Application for a non-material amendment following a grant of planning permission.

12 No. Social dwellings for Angmering Community Land Trust, including two communal bike stores, a pedestrian mews and orchard. Departure from the Development Plan.

| Reference number: | A/219/17/P |

Changes to certain materials/details , namely:-

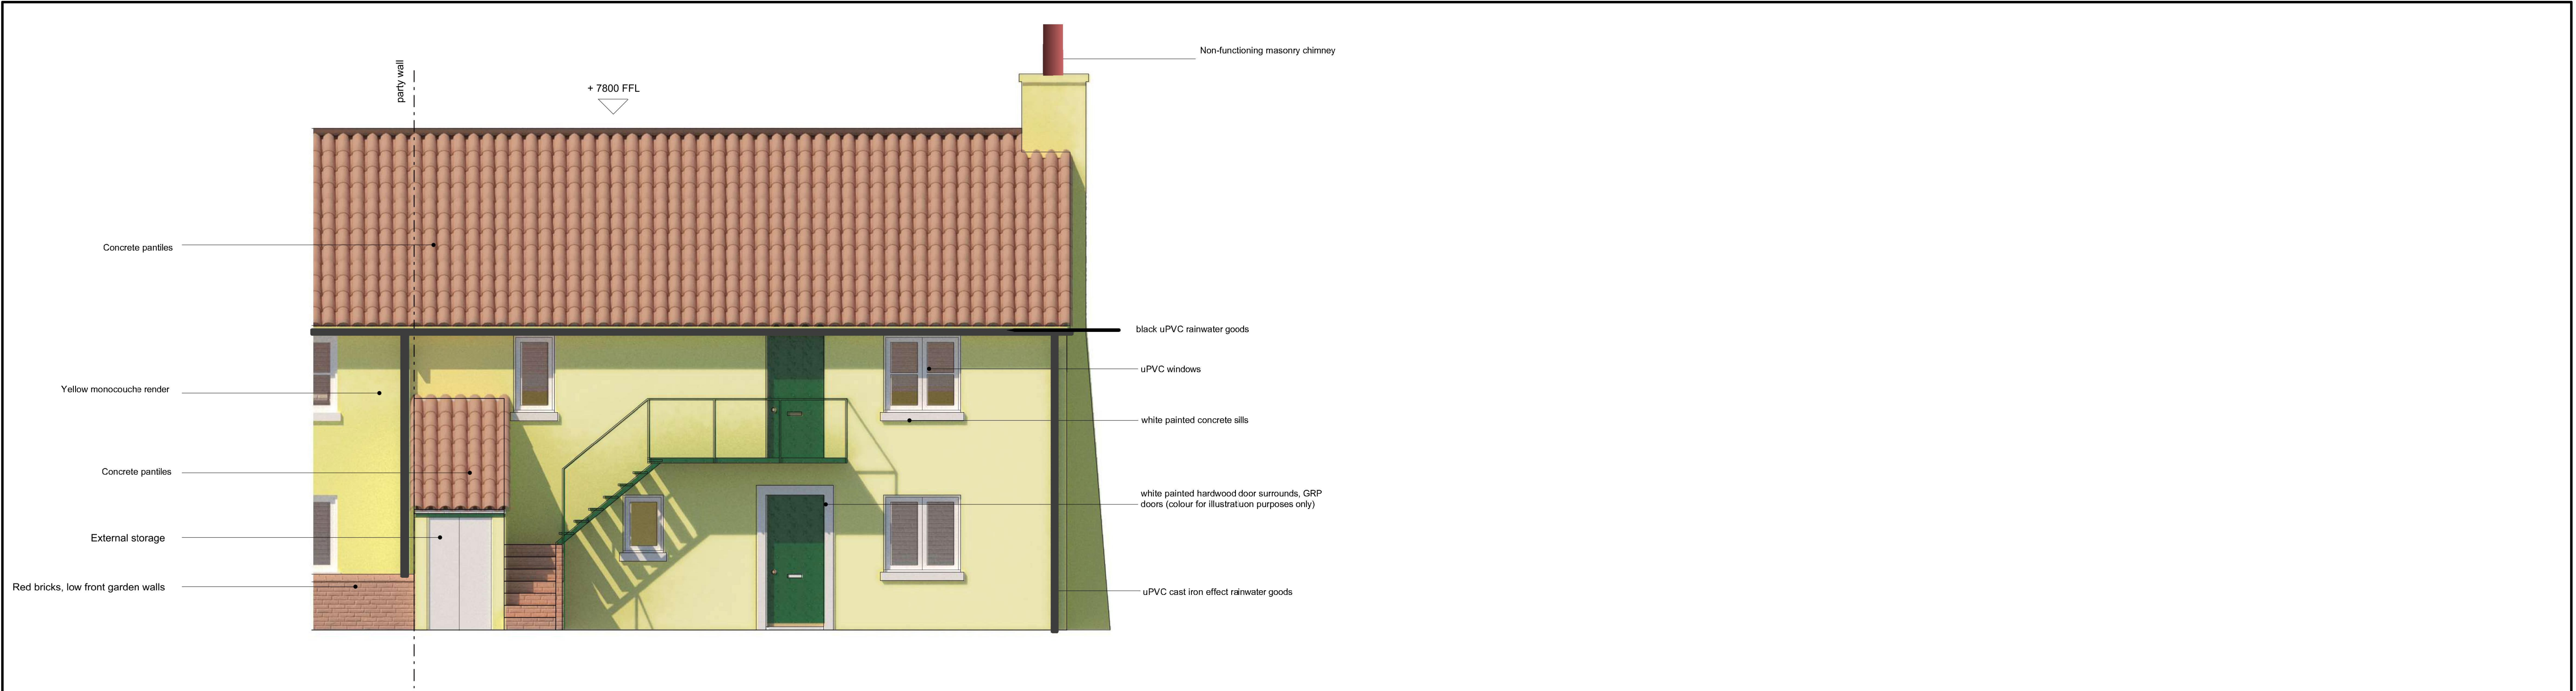
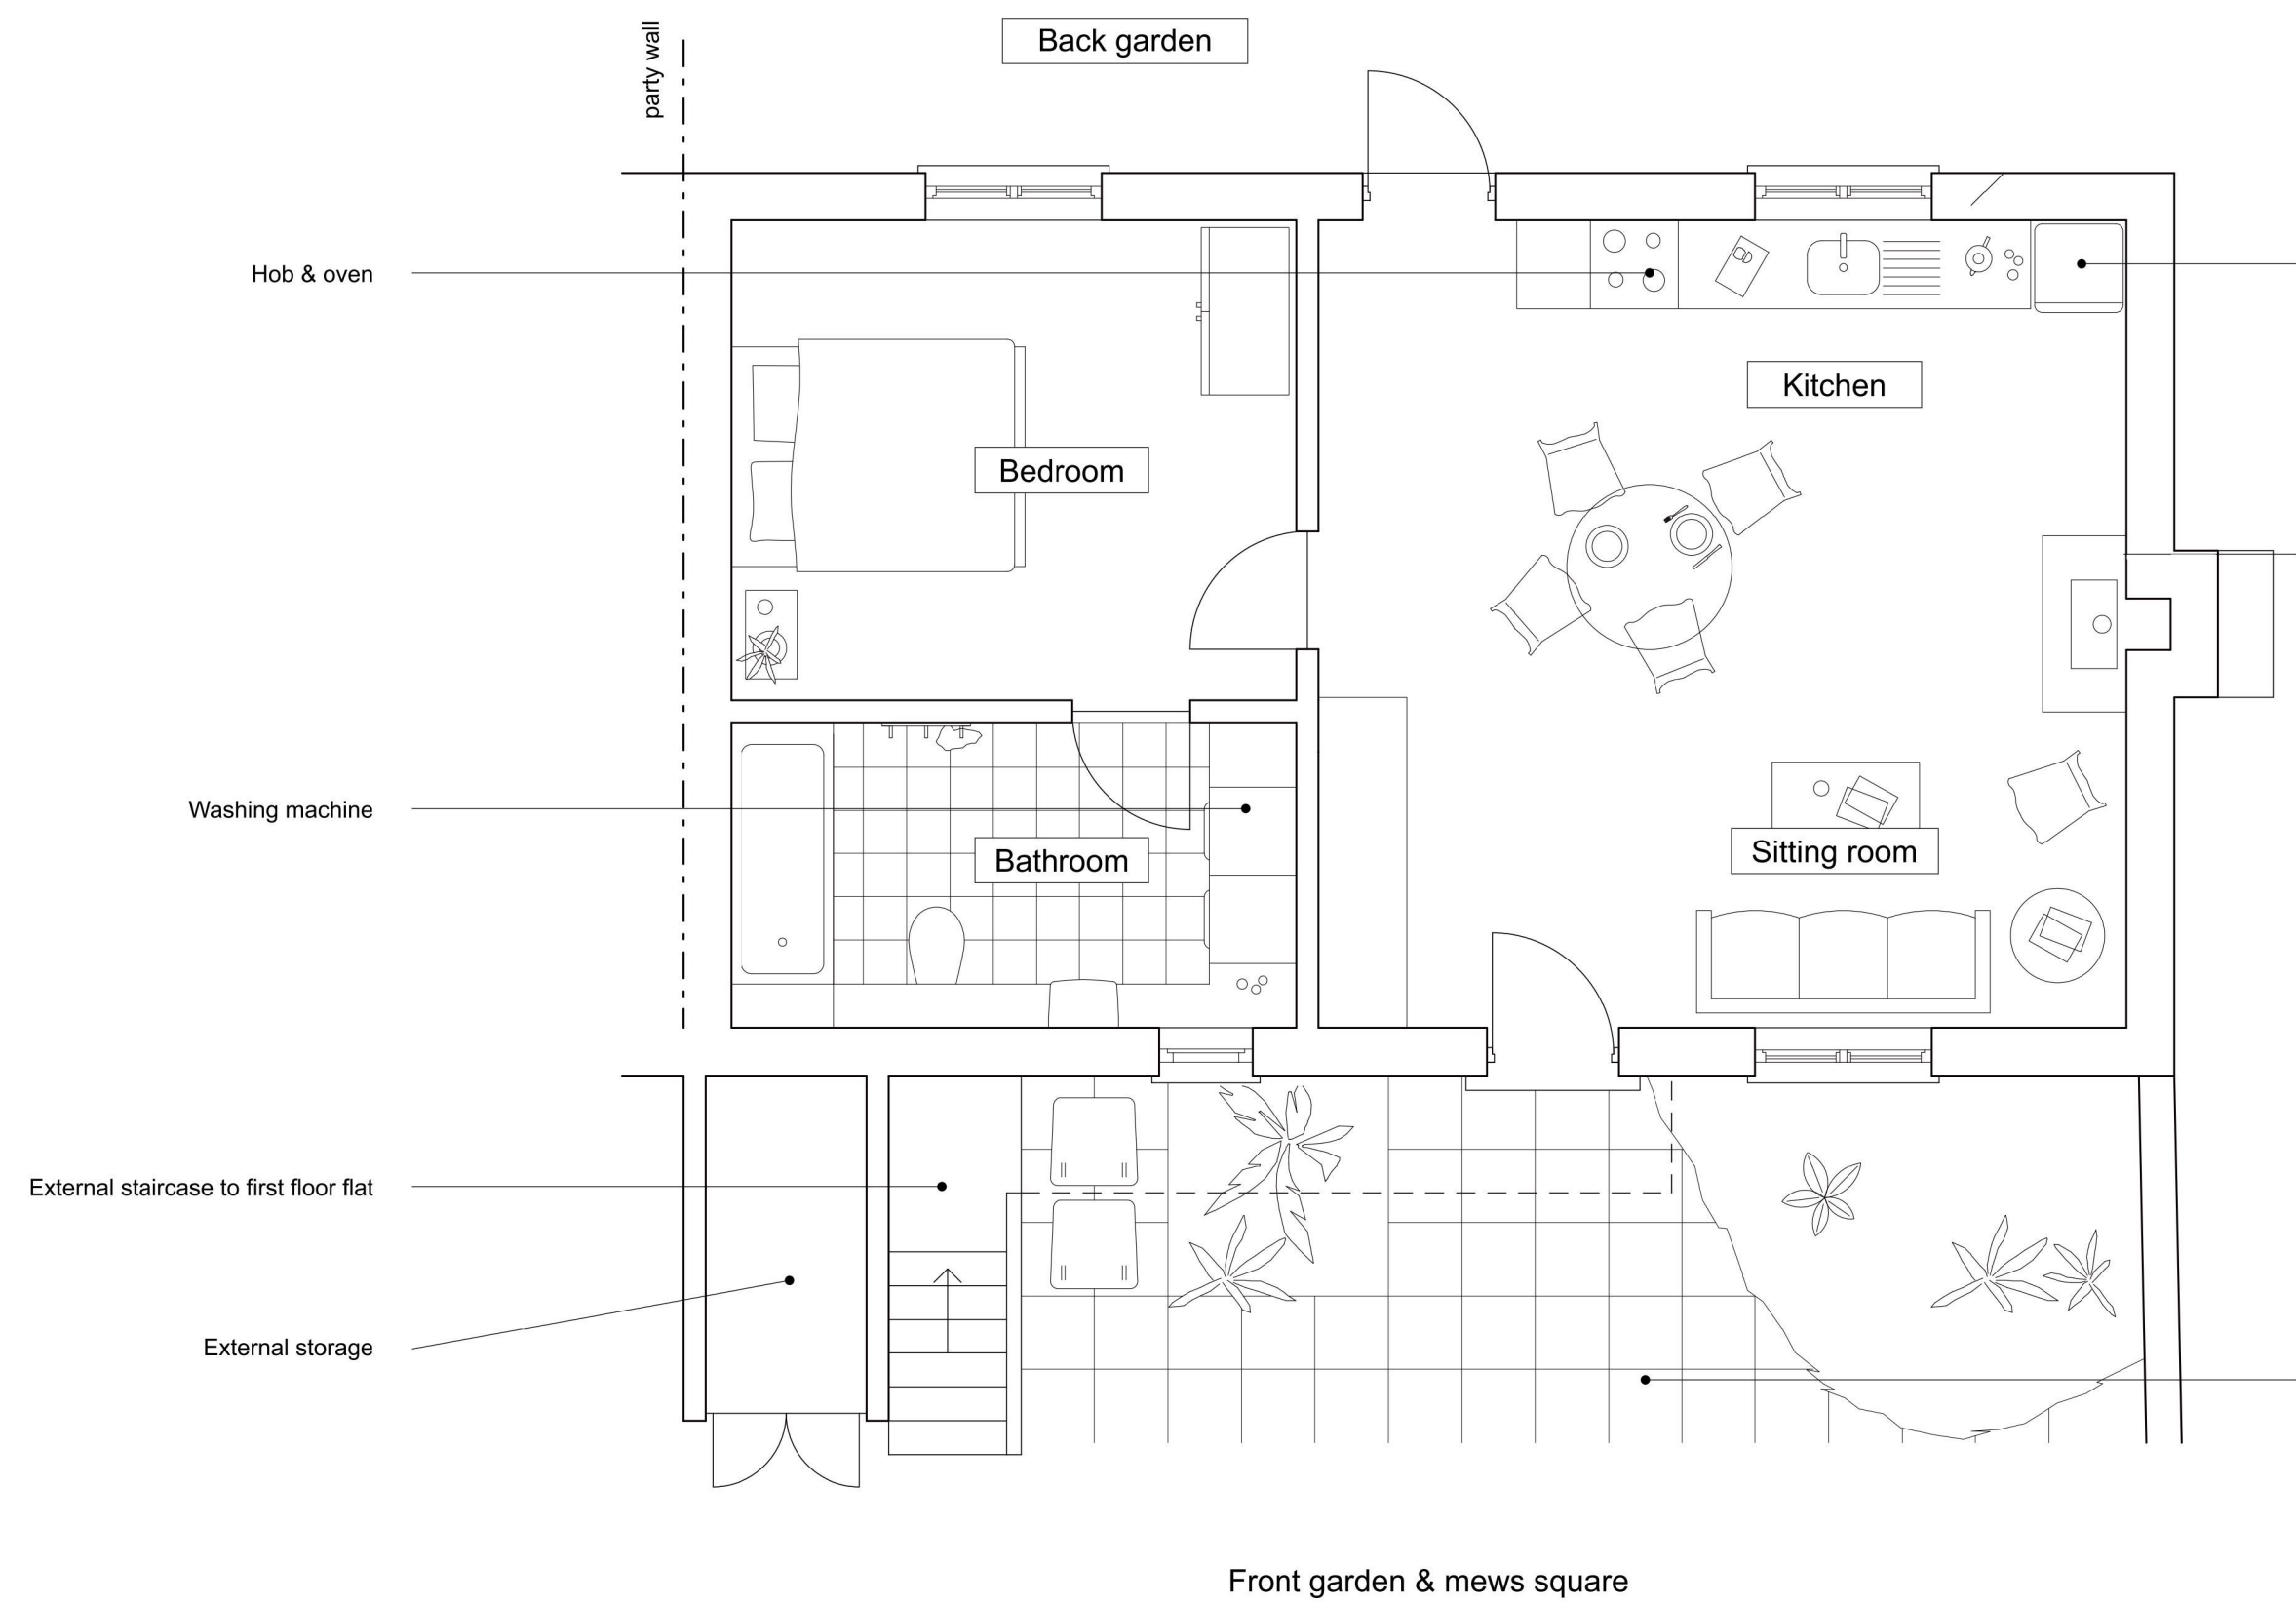
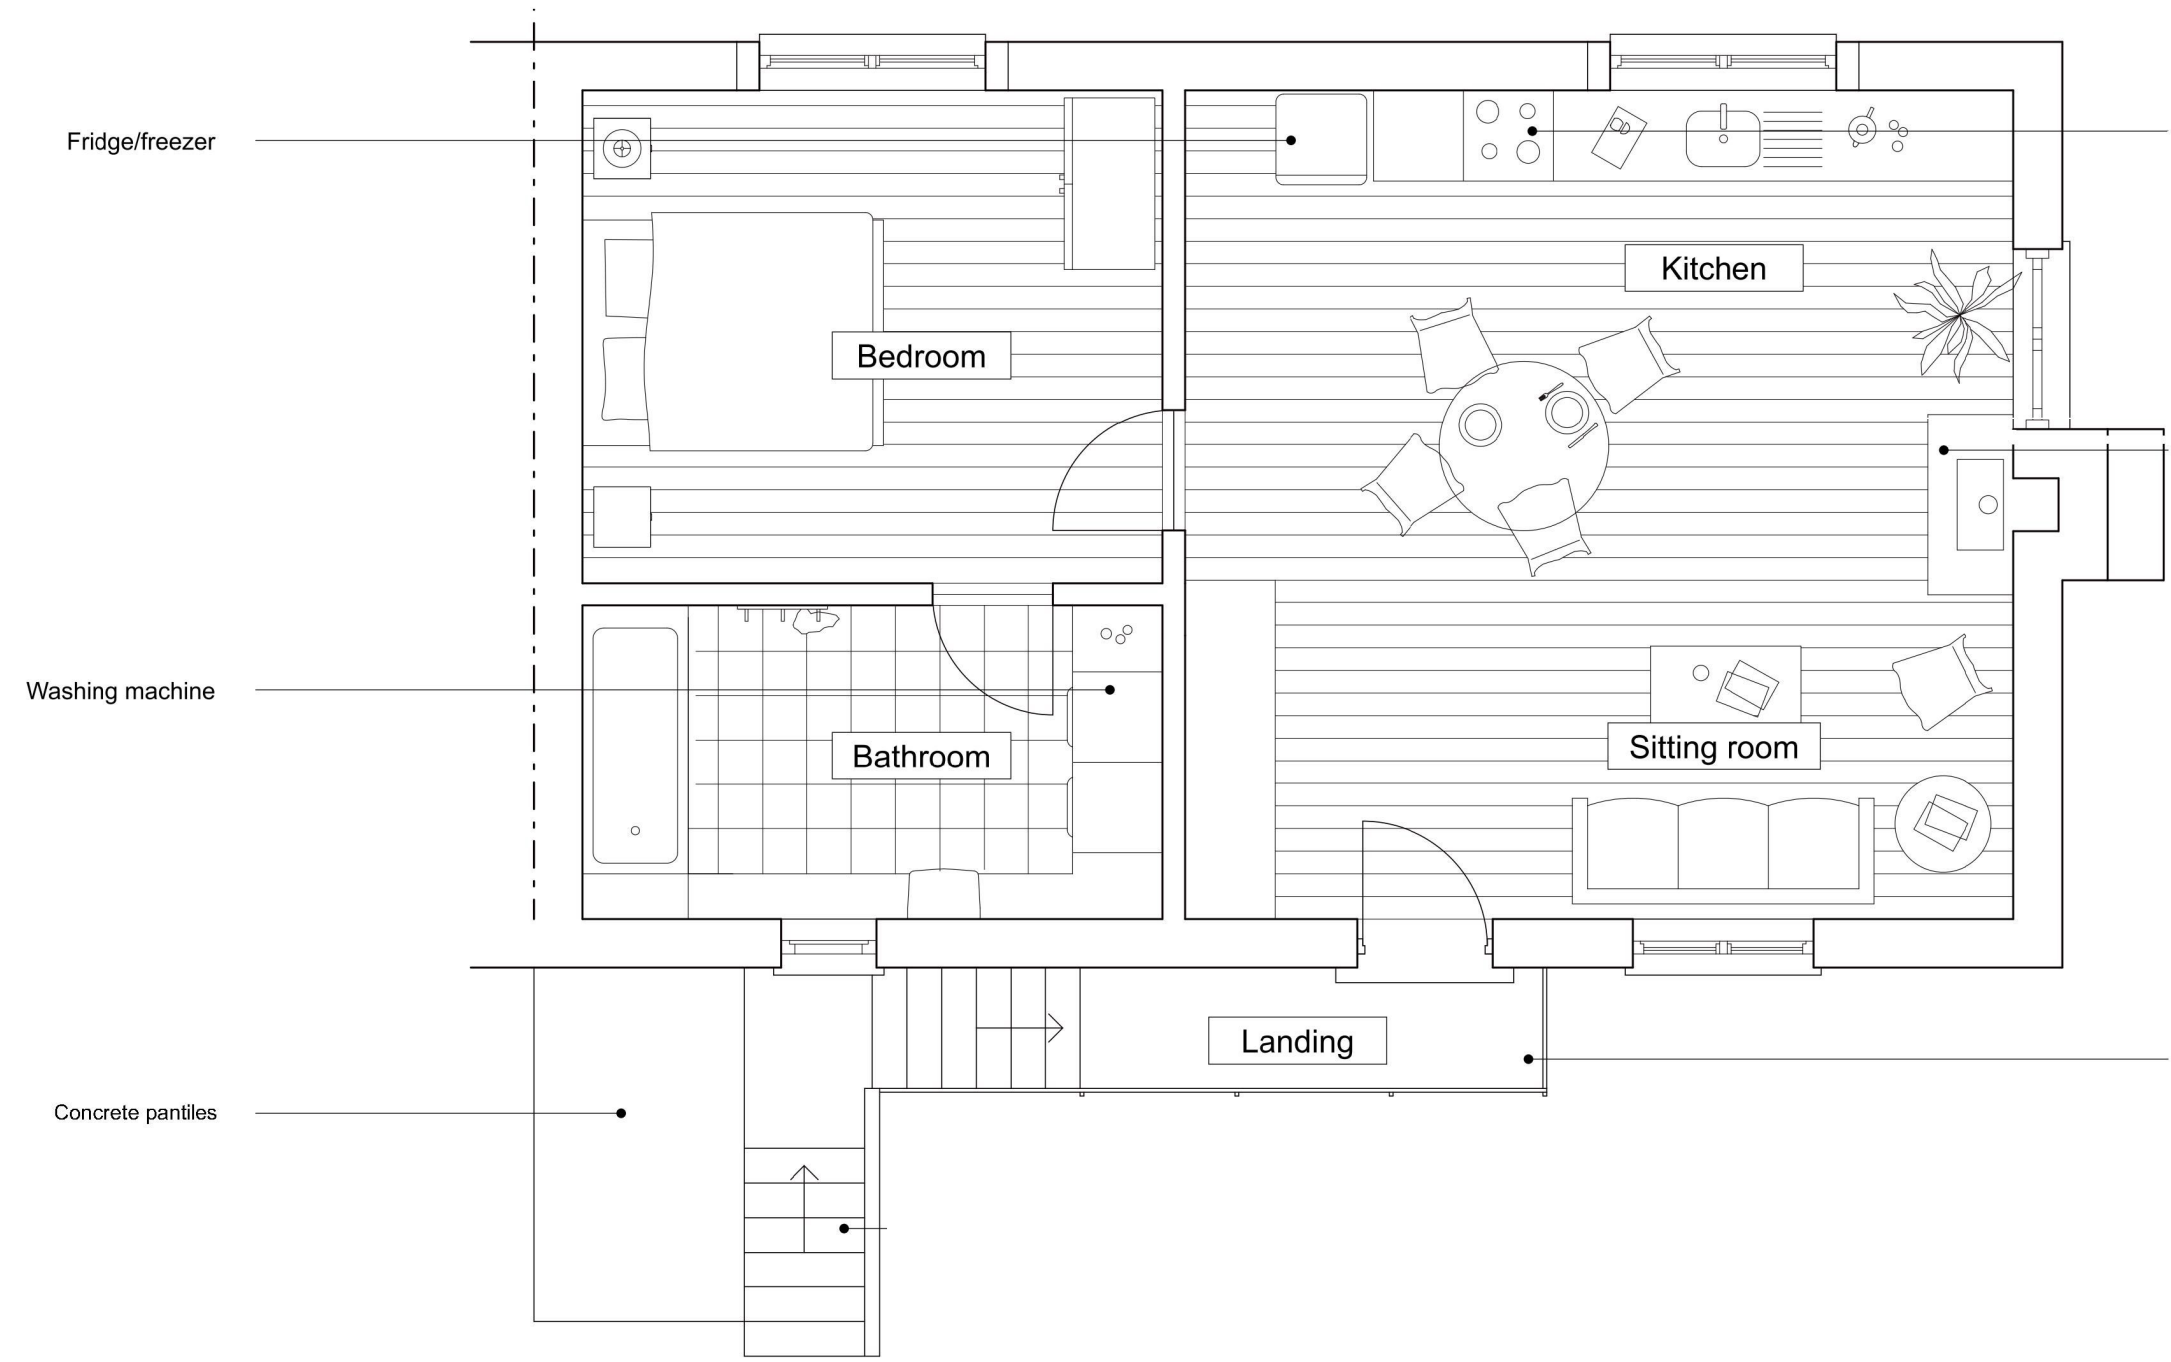
6Front doors to be GRP composite PAS24 while providing the same overall appearance. Reason: Development cost and on-going burden of cyclical maintenance.  
7 - Lintol treatment amended where noted on drawings: RSJ detail changed in favour of homogenous brickwork, & window jointol treatment amended as noted
